Reference: SF18/41152

**COMPLIANCE WITH CONSENT CONDITIONS
SSD 7484, The Sandstone Precinct**

- **Condition B44 B:** Schedule(s) of internal and external conservation works relating to significant heritage fabric both the Department of Lands Building (SHR00744) and Department of Education Building (SHR00726)
- **Condition B7A:** Nibs in Function Room 7 & 8
- **Condition B6:** Plans demonstrating that the Education Building entrance foyer design has been modified to retain/reuse a greater portion of identified significant fabric of the stone surrounds to the lifts.

PLAN DETAIL

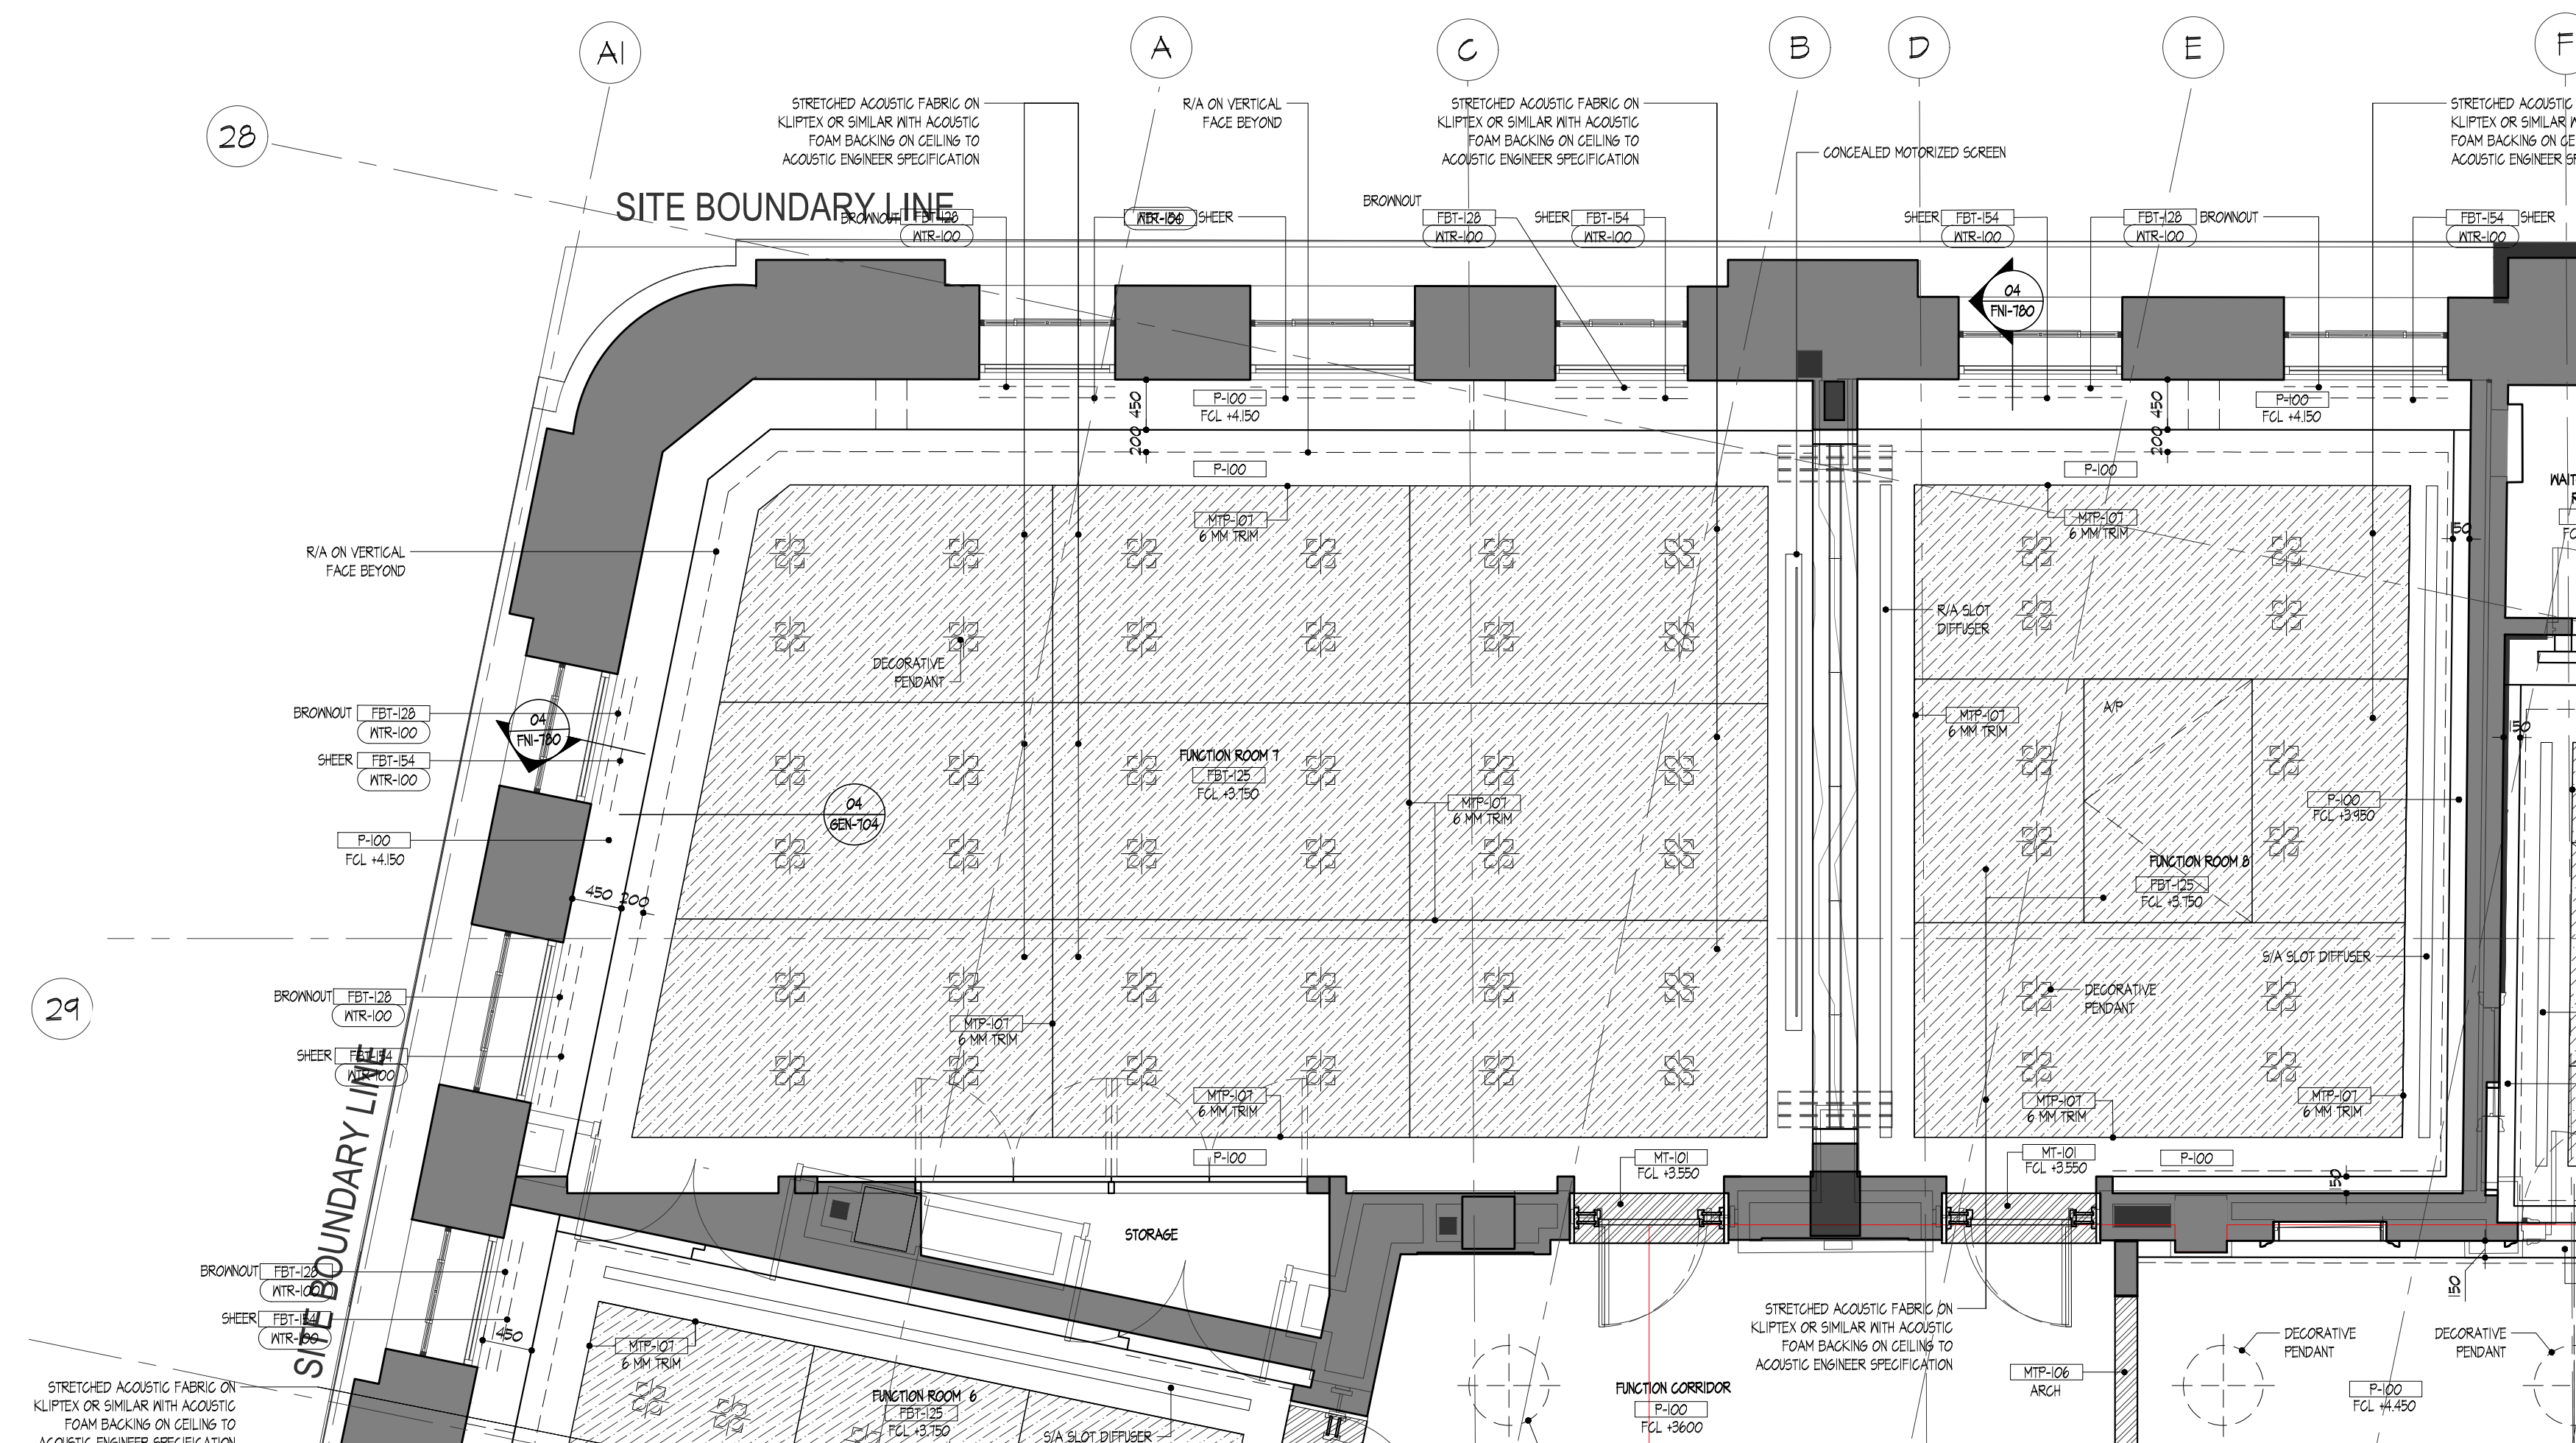
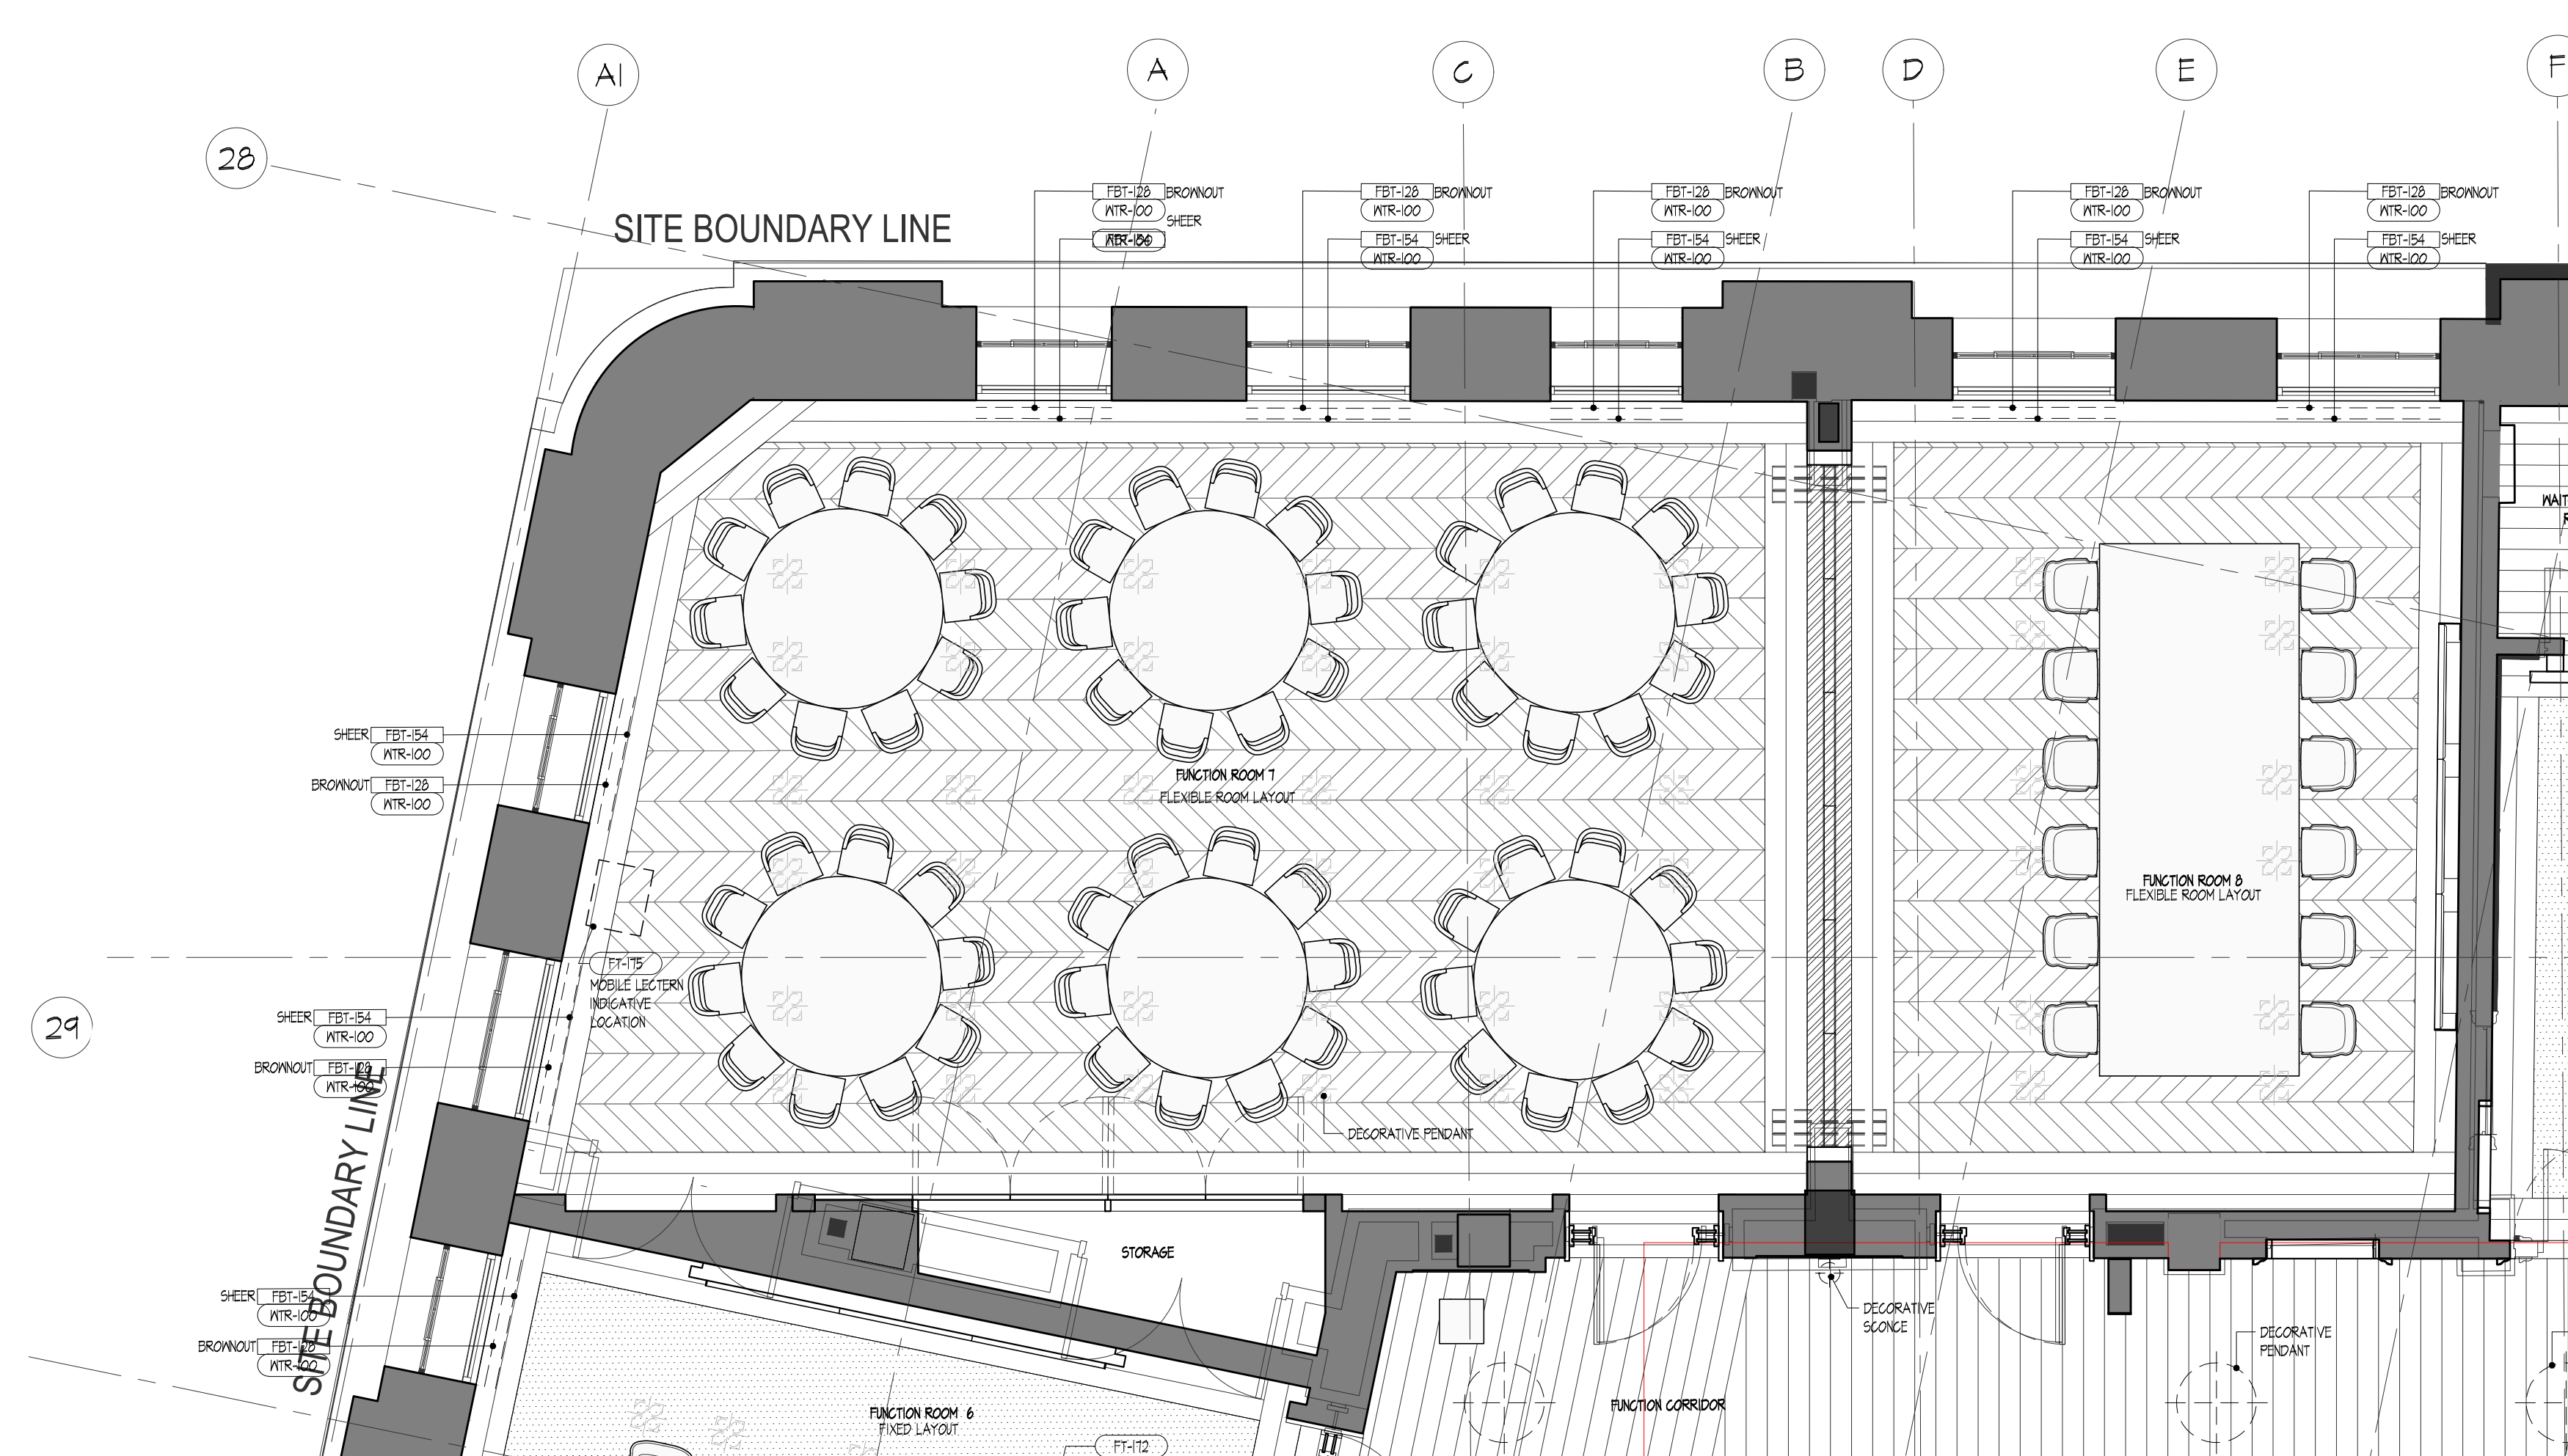
e) Prior to issue of Construction Certificate 3 – Foundations/ in ground structure (CC3), amended plans are required showing detailed design of the opening between function rooms 7 and 8. The plans are to show the retention of substantial wall nibs and head, and a line in the flooring to interpret the original wall configuration, prepared in consultation with the project heritage consultant, Heritage Council and Council, and submitted to the satisfaction of the Planning Secretary.

As delegate of the Heritage Council of NSW, I confirm that this information sufficiently addresses the requirements of the conditions and will satisfactorily fulfil the Condition of Consent for 'The Sandstone Precinct' SSD 7484 when implemented as described with the oversight of the nominated Heritage Advisor:
